Secretary
Department of Planning, Industry and Environment
320 Pitt Street
SYDNEY
NSW 2001

Sites 2A and 2B Australia Avenue, Sydney Olympic Park (SSD-9383)

I refer to your request for comments on SSD-9383 for the development of Sites 2A and 2B, Australia Avenue, Sydney Olympic Park (the site).

5.8 *Ficus macrophylla* – Root Impact Plan

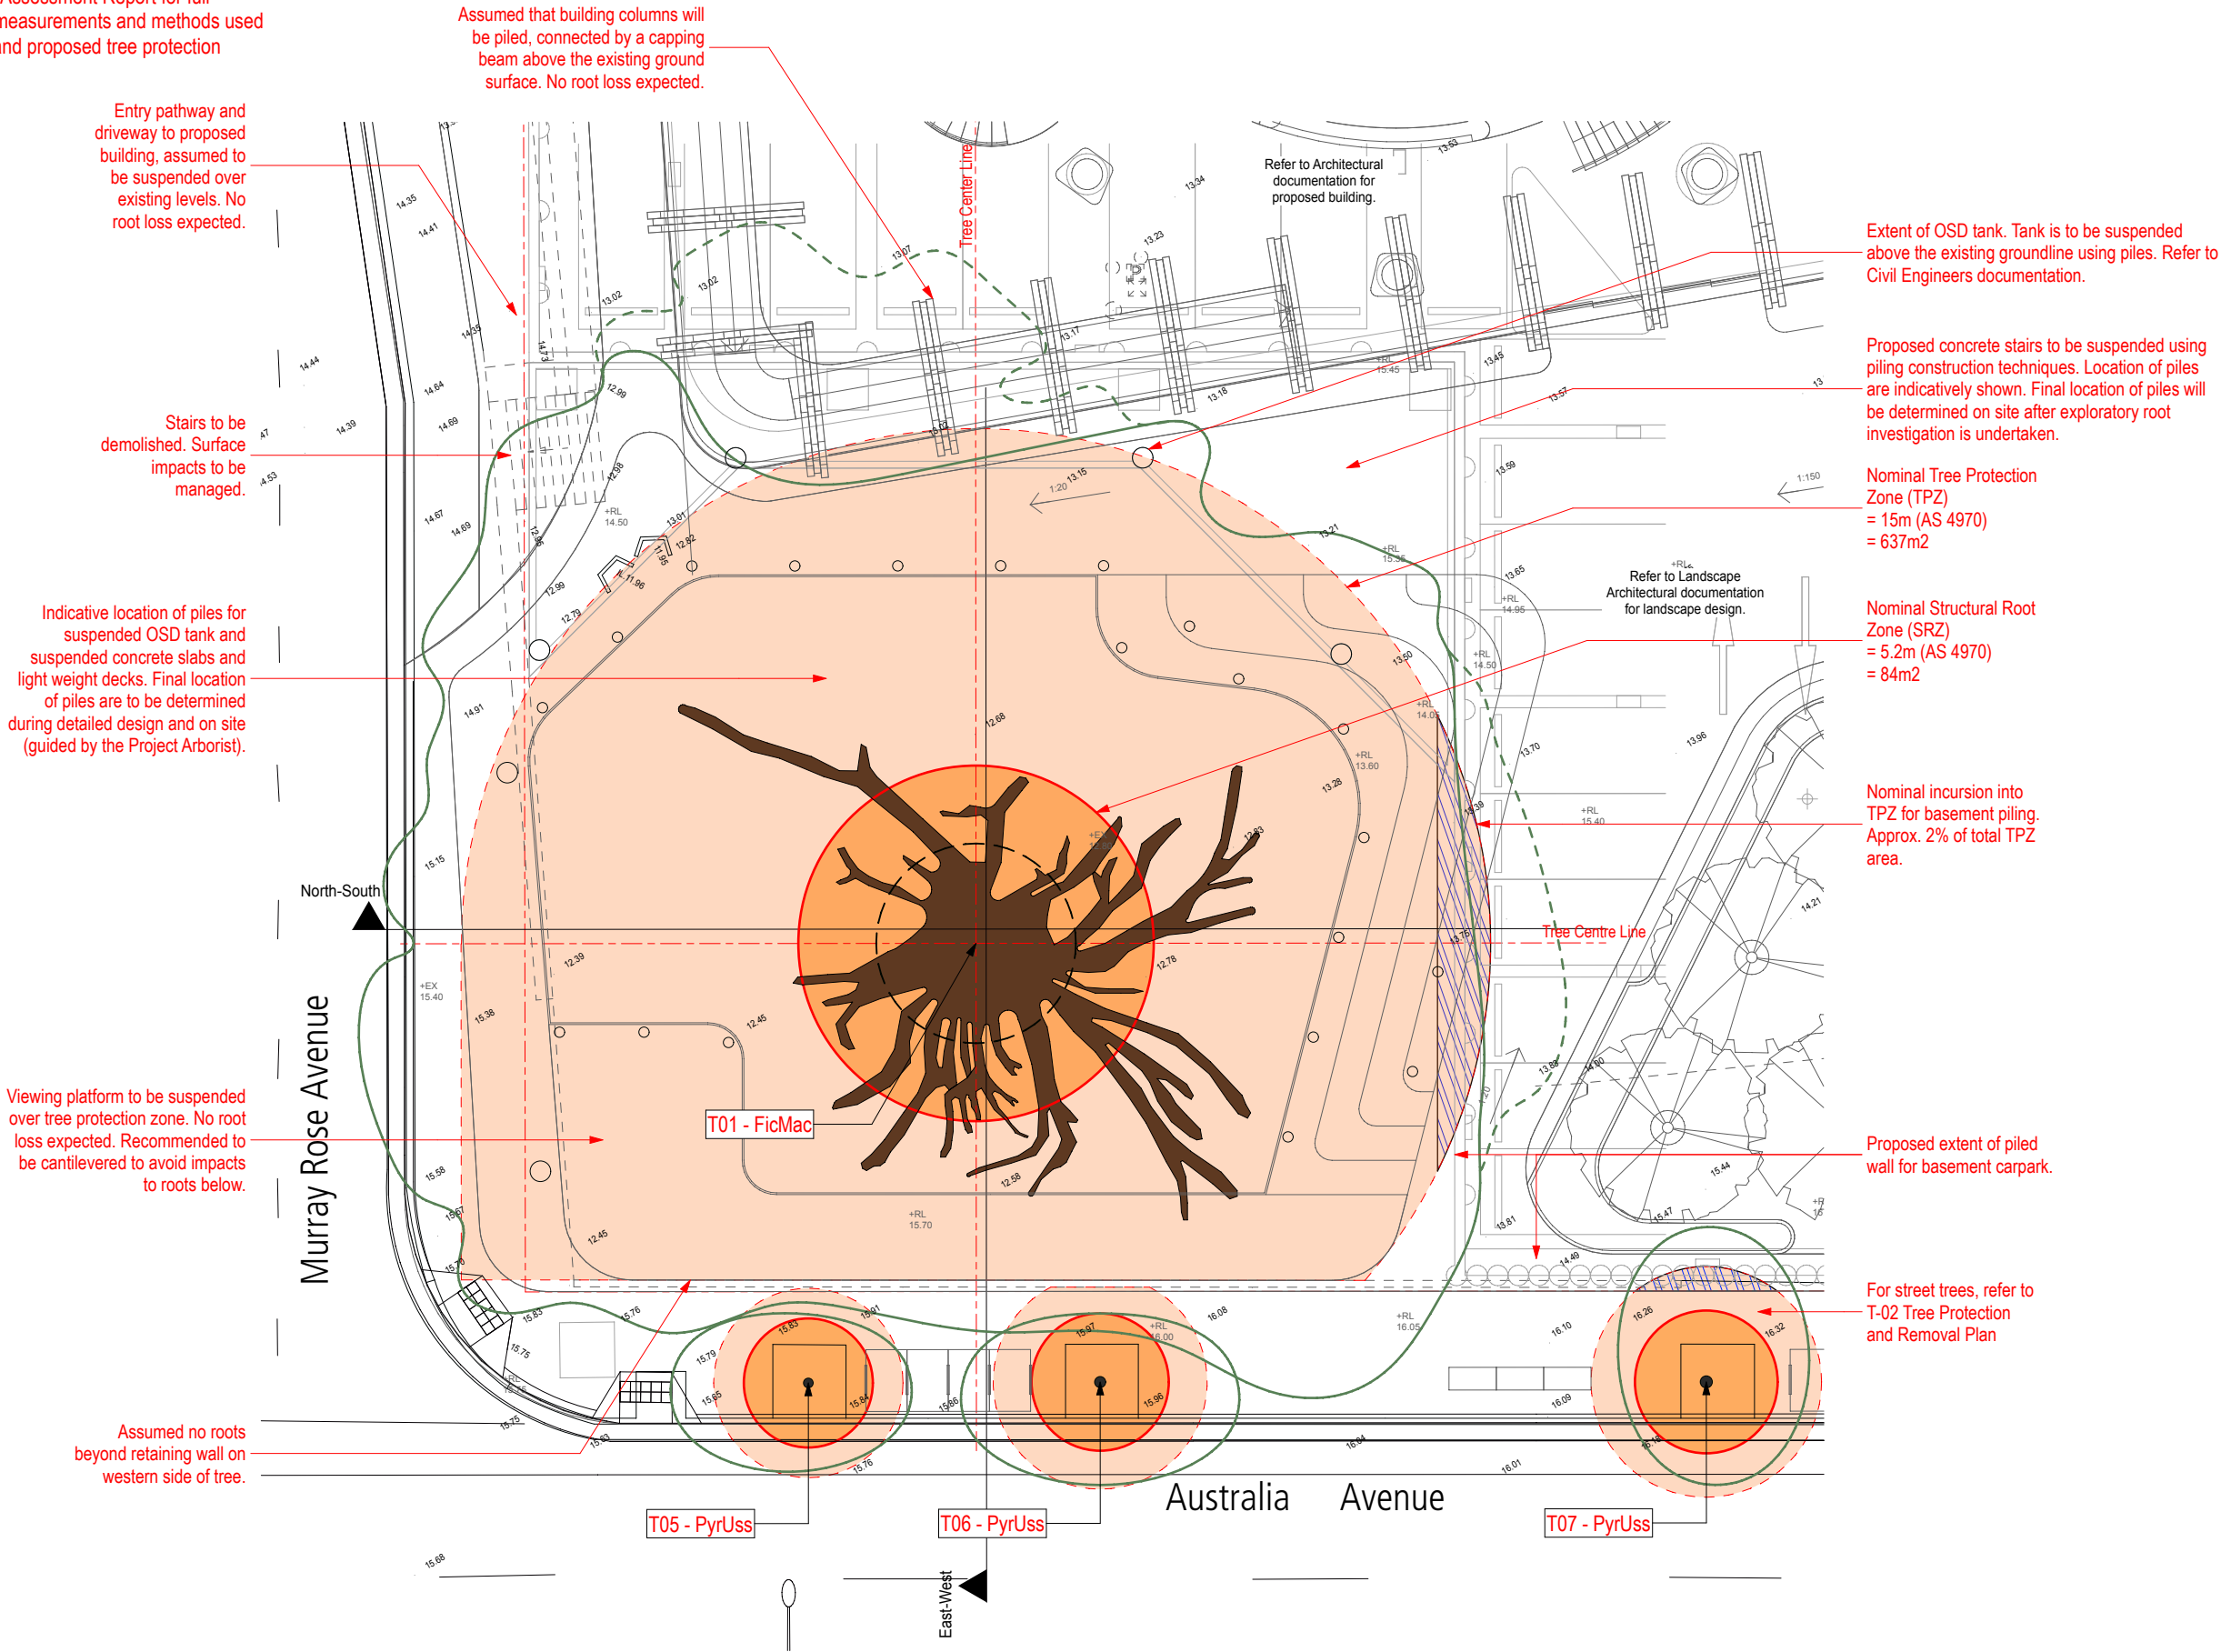
It is also identified that another existing Moreton Bay Fig Tree to the east of the site may be impacted as a result of the development. This tree is located outside of the site, yet has root and canopy cover extending into the site. Accordingly, non-destructive root mapping needs be undertaken to verify the location of the major roots and guide the location for the basement wall along the eastern boundary.

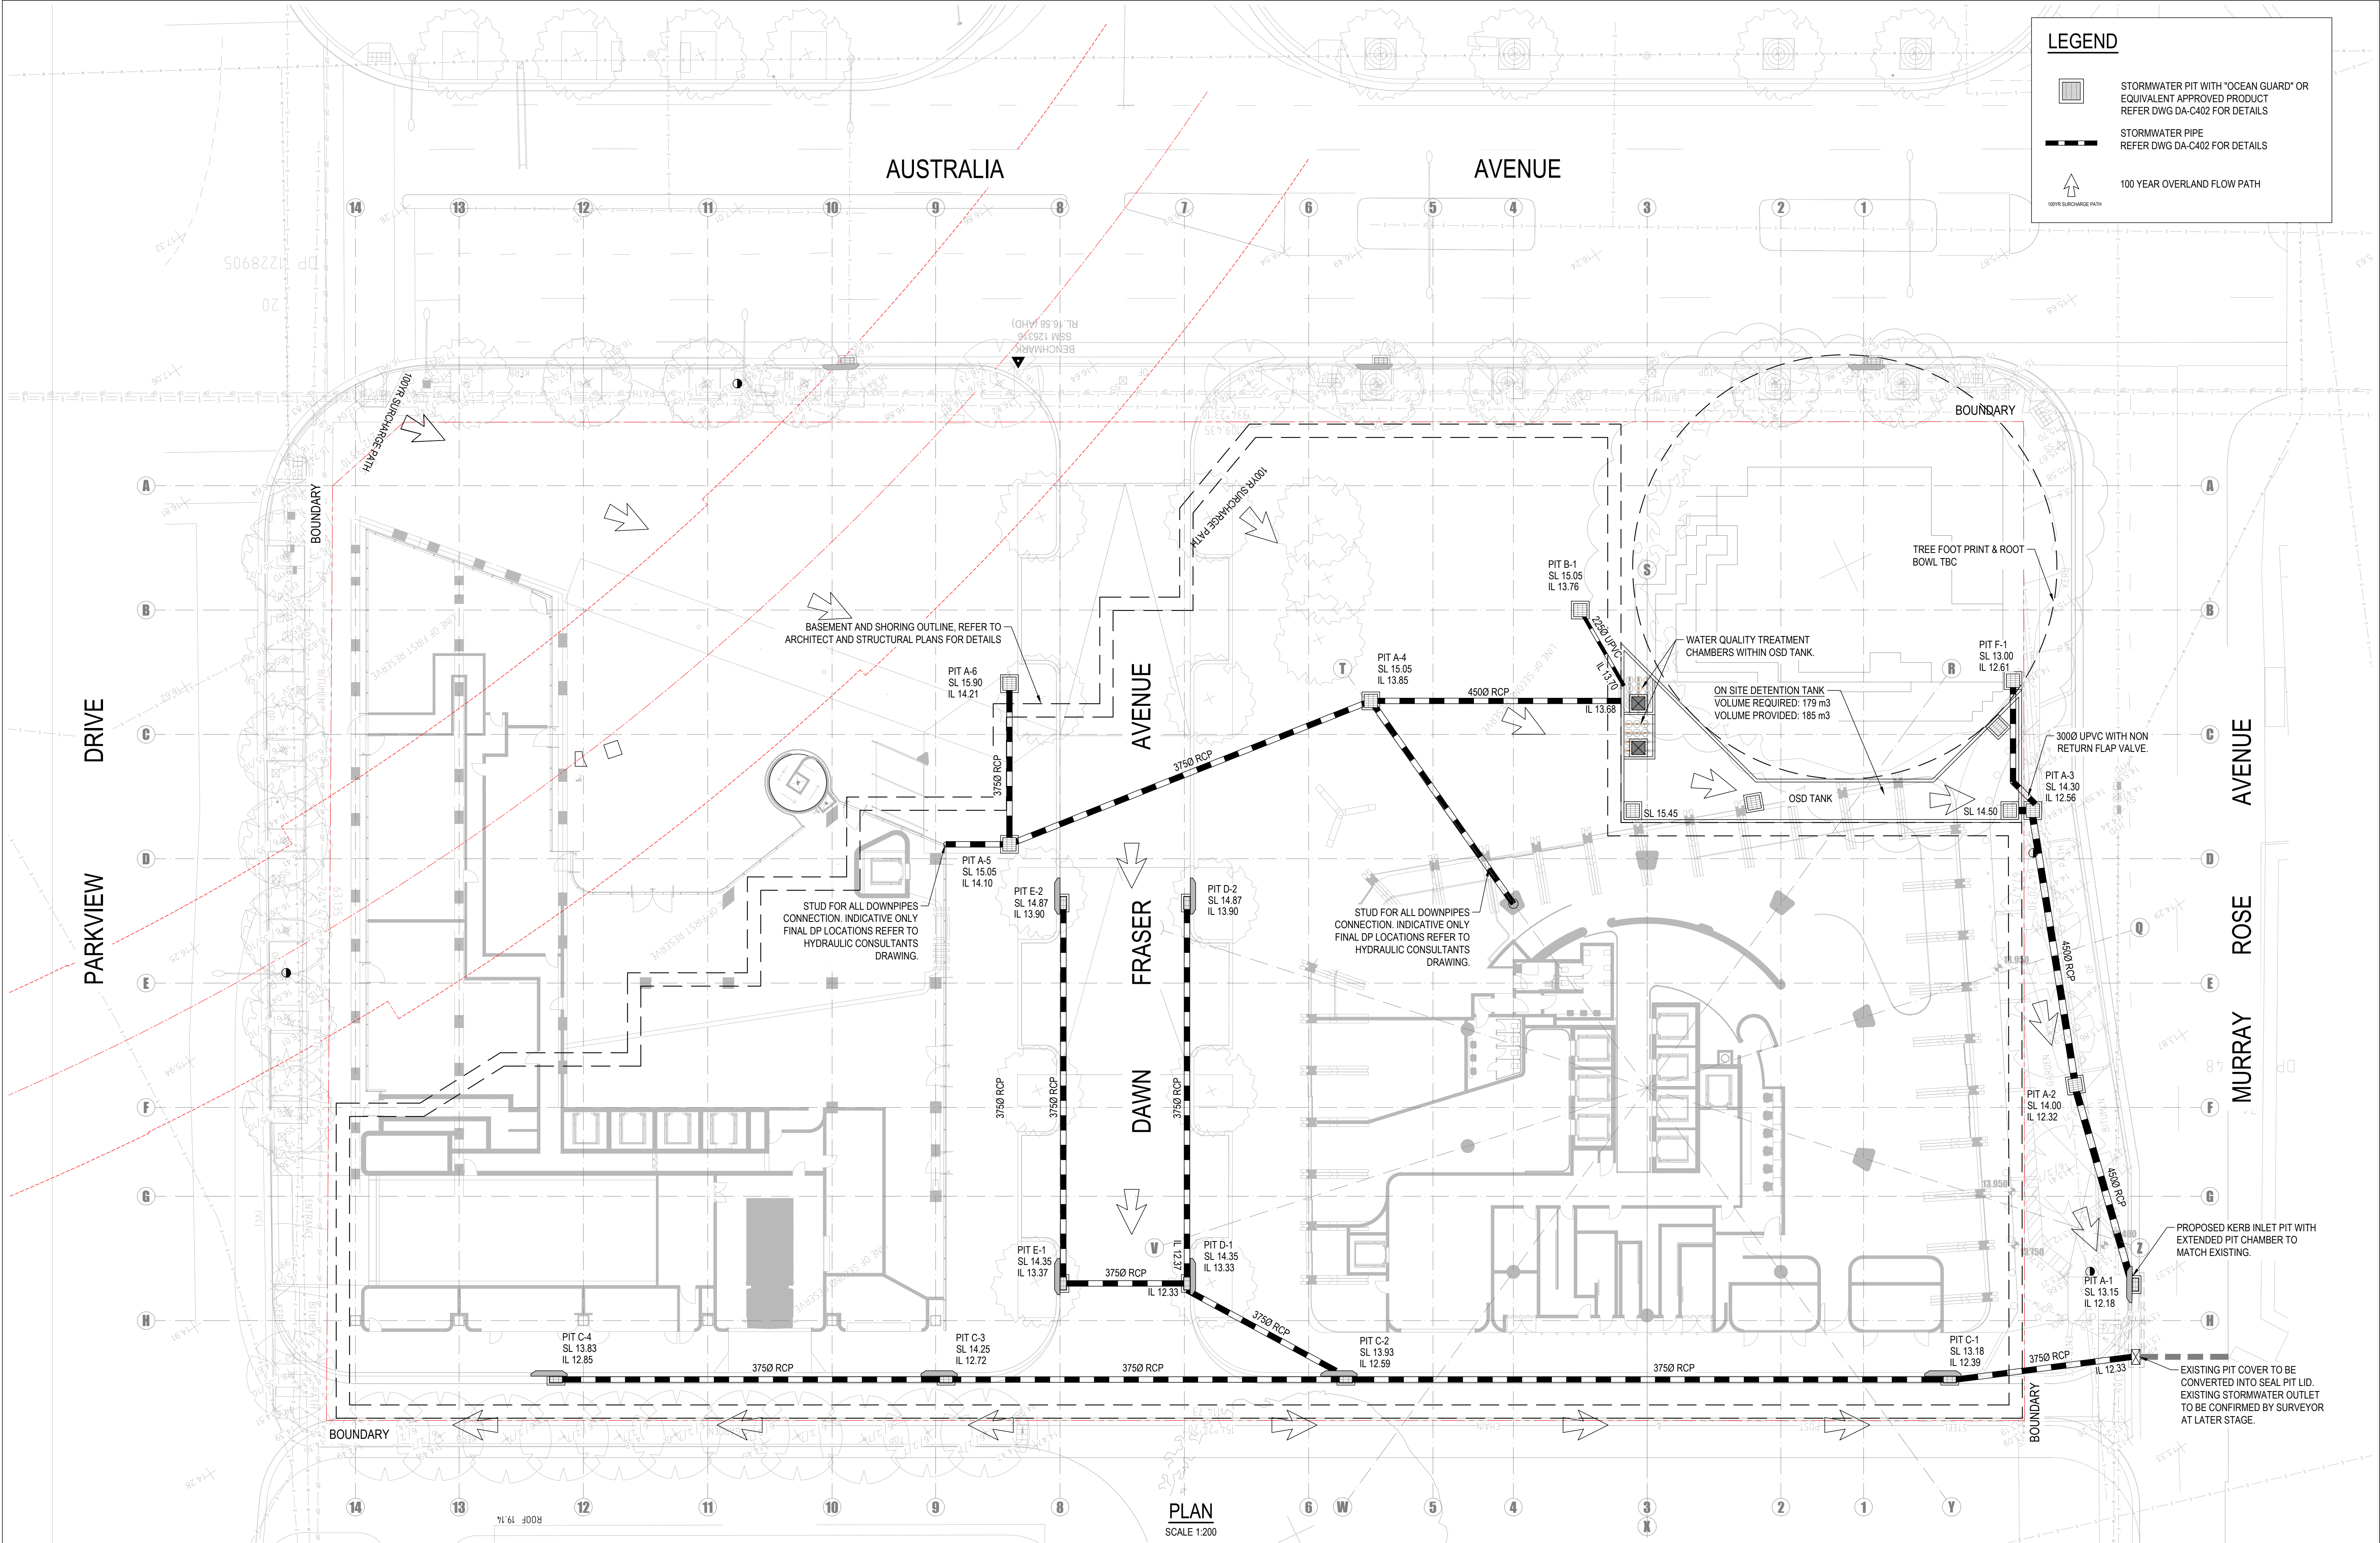
SOPA advises that the expectant drainage assumptions for the sites are inaccurate, the identified discharge point for the stormwater drainage is identified to be decommissioned and that the proposed layout imposes a risk of flooding to the activated area around the fig tree.

In addition, the area around the fig tree needs to be assessed from a flooding and risk perspective. Further, only the low podium (around the fig tree) and the street may be connected to the drainage pipe at low level.

With regard to stormwater drainage, the pipe shown in the image below (Figure 2) must be made redundant and the street inlet pit be directly connected to the bio-swale on the opposite side of the road with a new pipe and headwall (the orange arrow). This change will have significant impact on the fig tree's water intake. Therefore, irrigation should be considered for the fig tree.

Further, the surface run-off from Dawn Fraser Avenue east must be drained to the tree pits with erosion measures for erosion prevention.

SOPA requests detailed stormwater drainage plans be updated and submitted to SOPA for review and comments prior to any determination. All plans must be in accordance with SOPA's WSUD Policy.
